Date: 09 February 2022
Our ref: 377597
Your ref: P/167/21/RES & P/153/21/RES

Planning consultation: Reserved Matters (appearance, layout, landscaping & scale) for outline P/140/16/OUT for the erection of 375 dwellings, together with public open space, play space etc.

Location: Land South of Summer Lane and West of Pagham Road Pagham.

FURTHER INFORMATION REQUIRED TO DETERMINE IMPACTS ON DESIGNATED SITES

3.0 UPDATE RECREATIONAL IMPACT ASSESSMENT

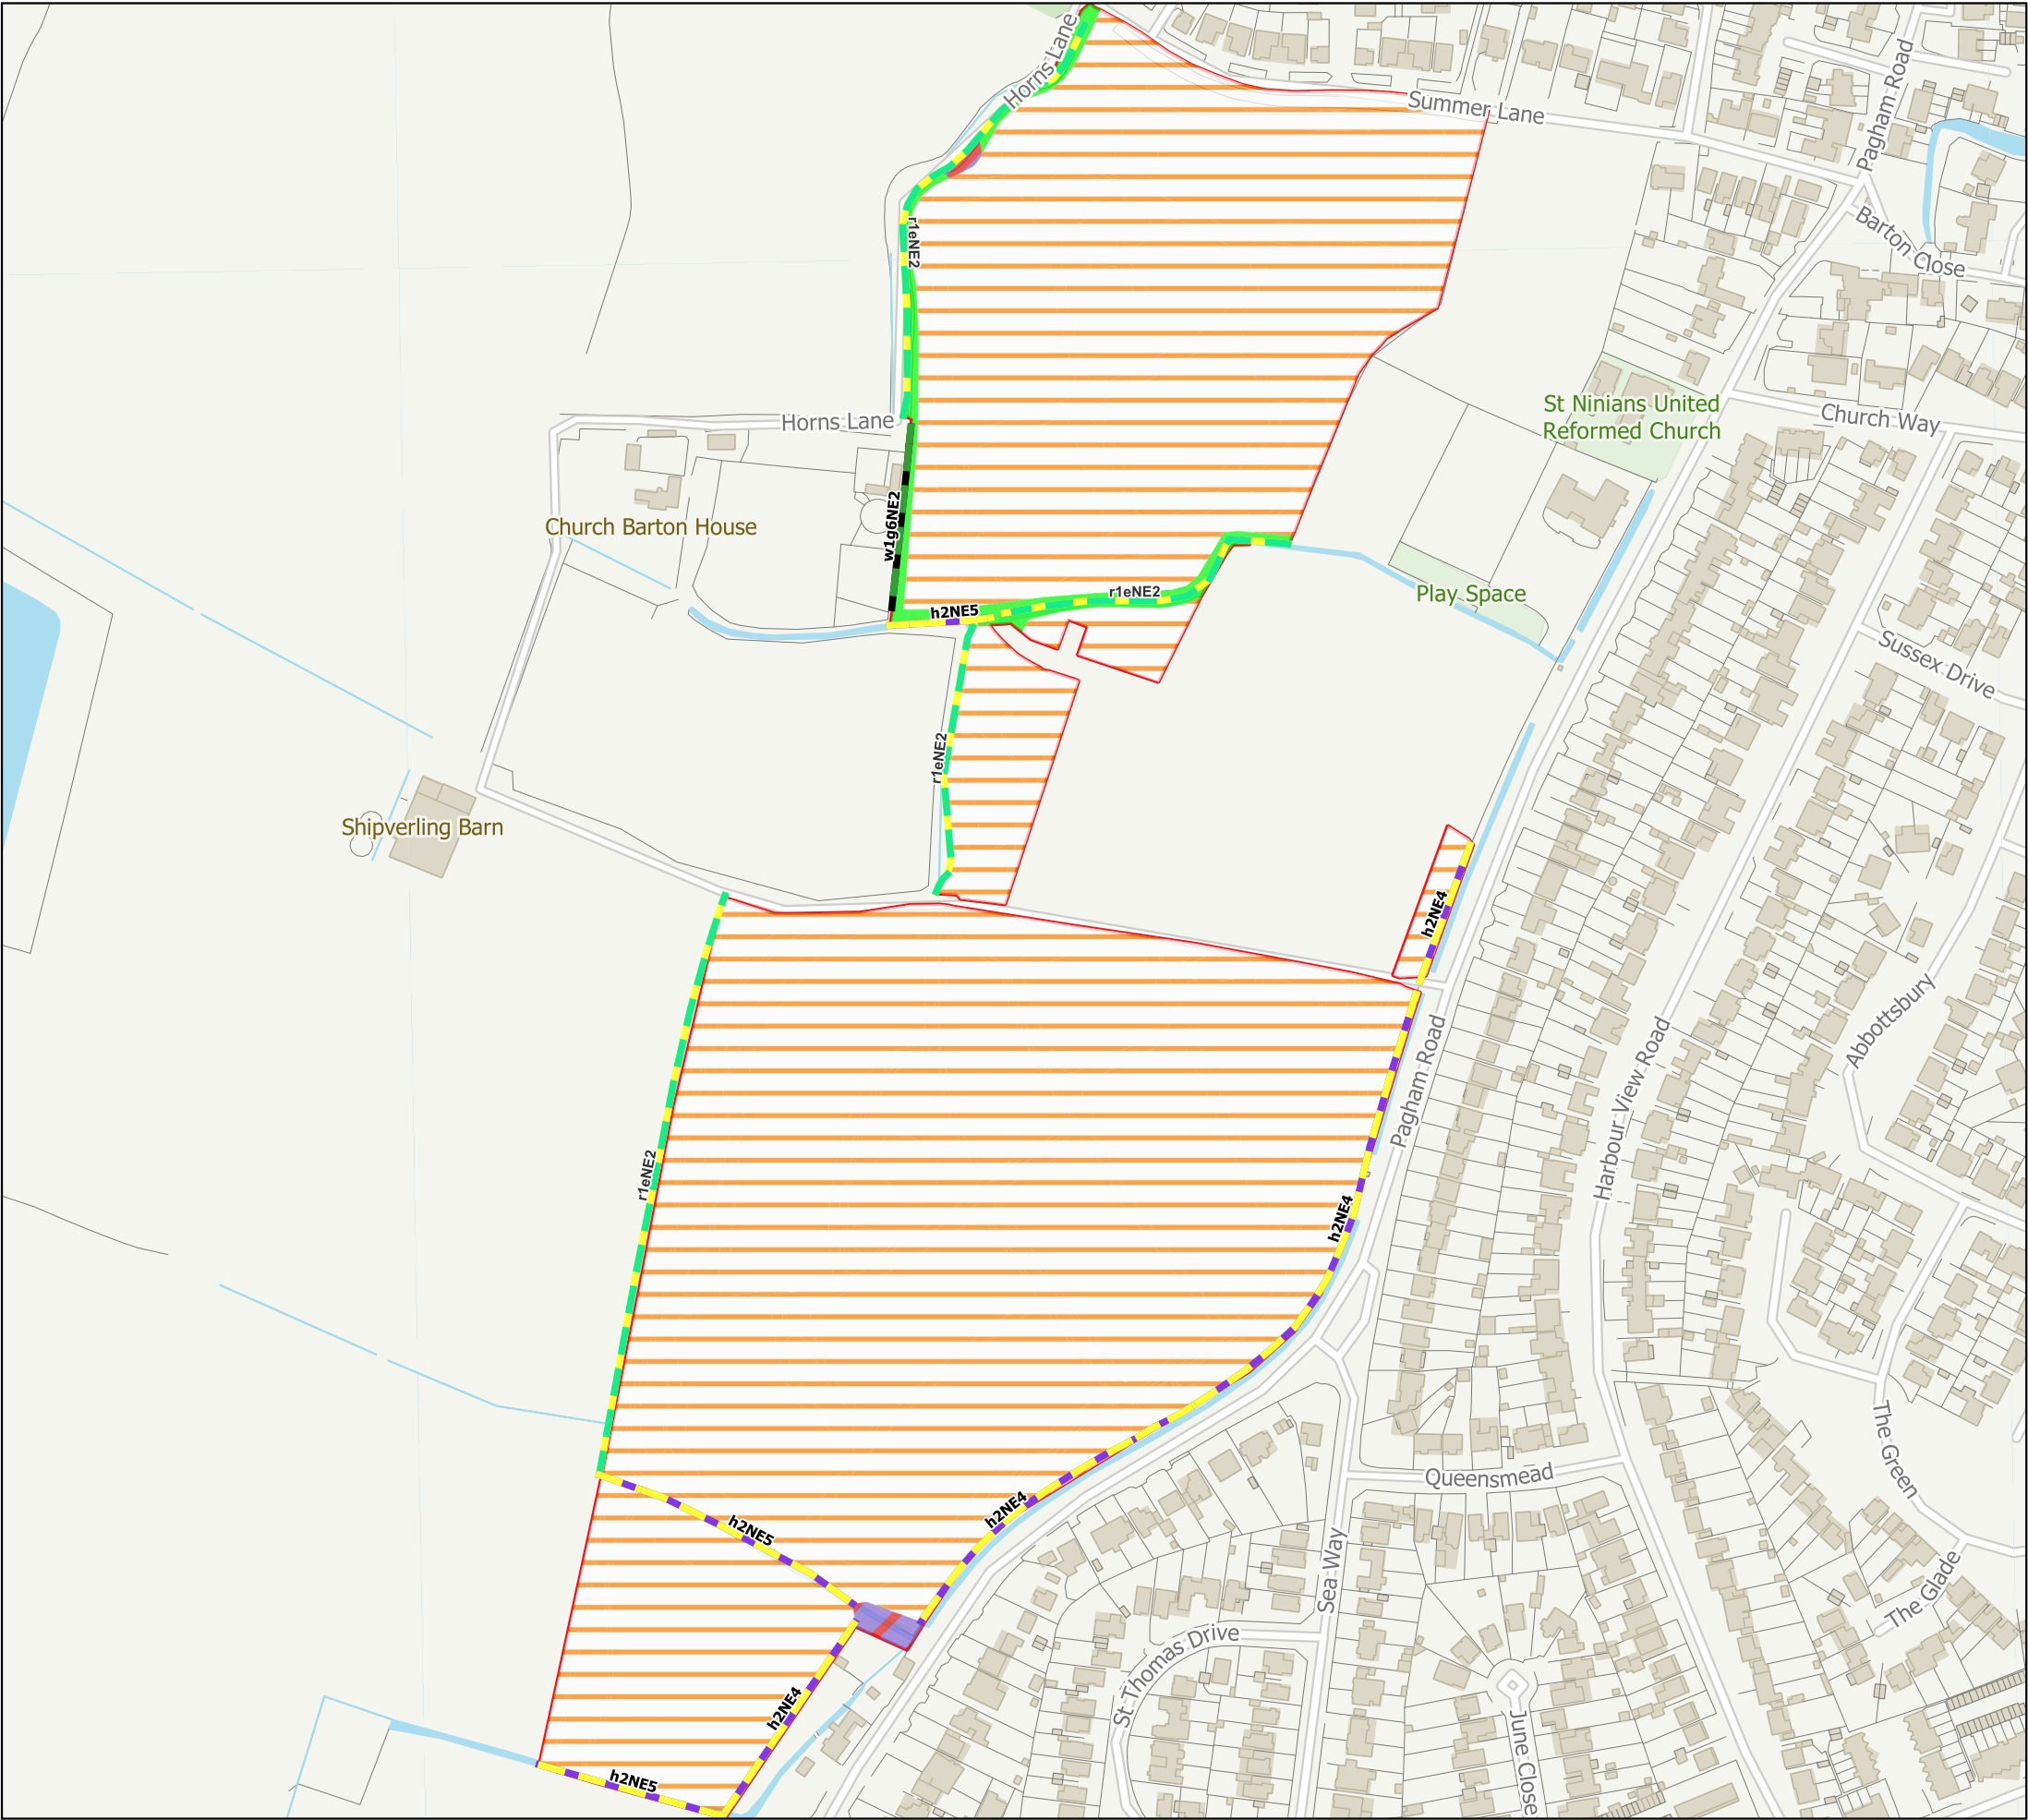
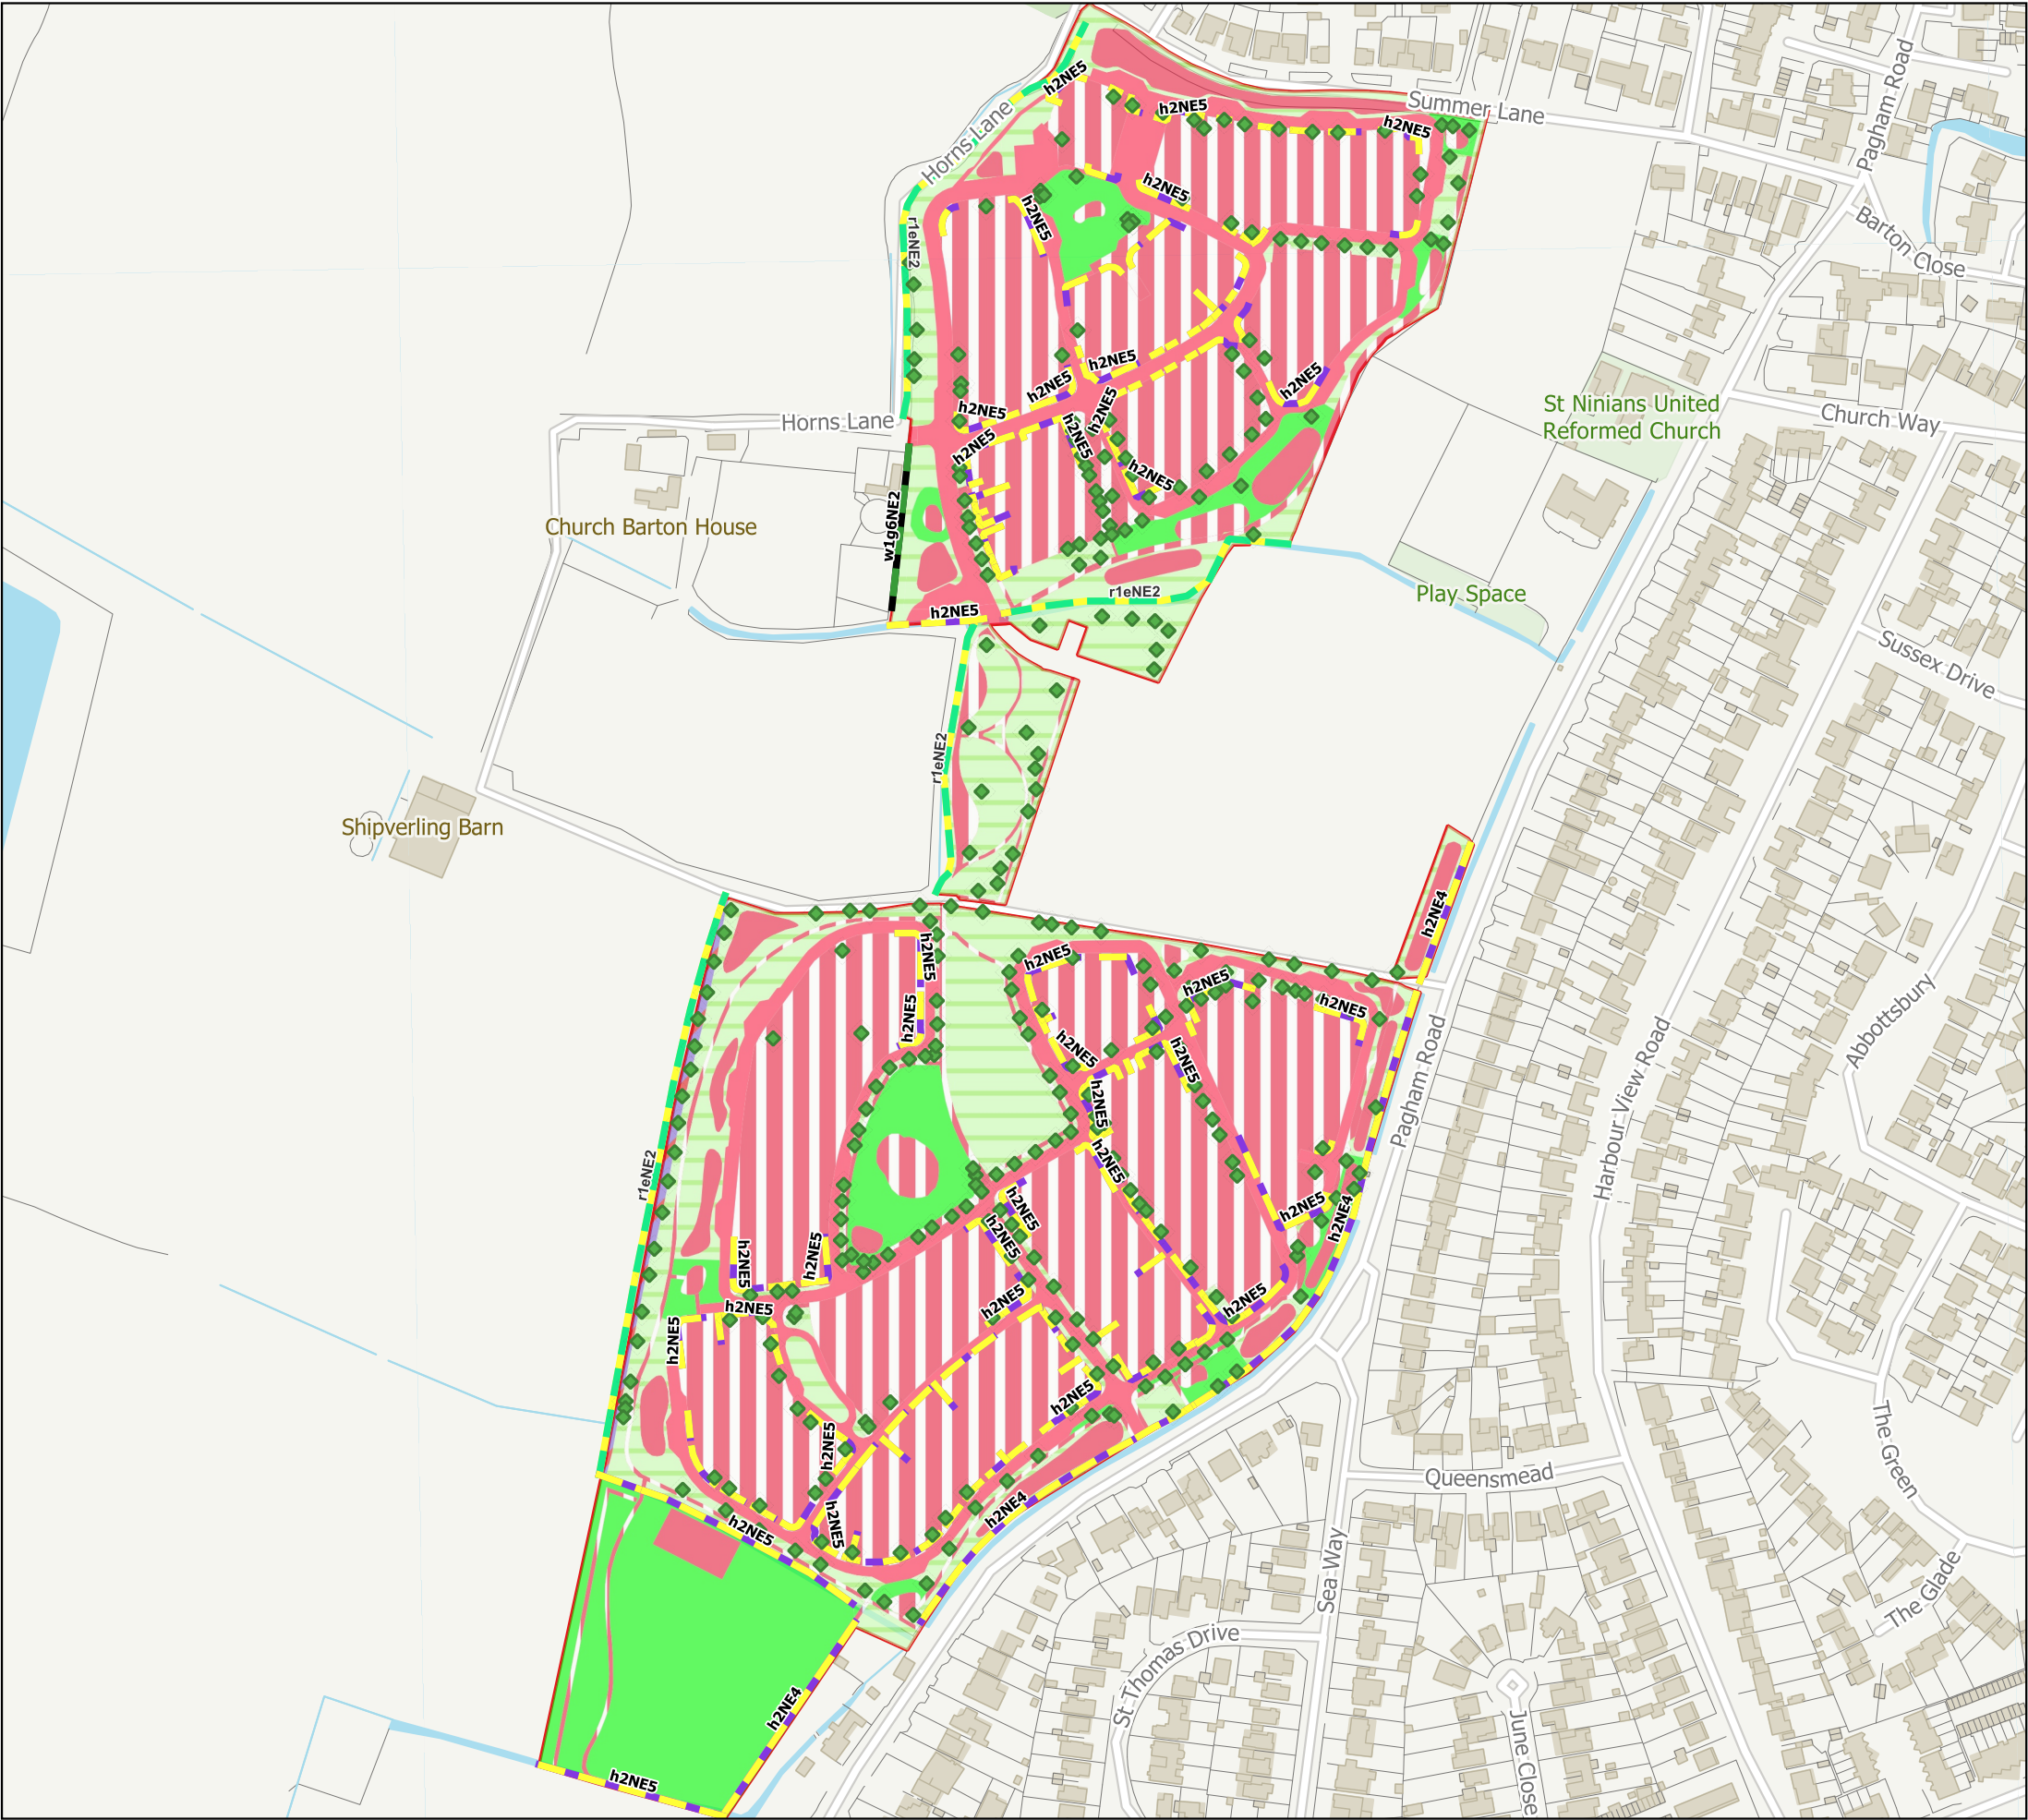
As per our response on the Outline application P/140/16/OUT (our ref: 259977, 18th October 2018), Natural England advised that given the history of Brent Geese foraging in the fields to the west of the application site, the landscaping plan should include details of thick hedging, reinforced by fencing, along the western boundary of the site. Having reviewed the information provided under this Reserved Matters application, it remains unclear as to how this advice has been incorporated within the landscaping design.

In addition to the uncertainty surrounding the inclusion of suitable screening along the western boundary of the site, it is equally unclear as to whether the current layout of the site is able to facilitate the proposed 3.92ha of on-site greenspace within the development site. Whilst Natural England recognises that consideration has been given to its management of the greenspace within the S106 agreement for the Outline application, having reviewed the proposed block plan for the site it is unclear as to how 3.92ha of on-site greenspace shall be appropriately accommodated within the proposed layout.
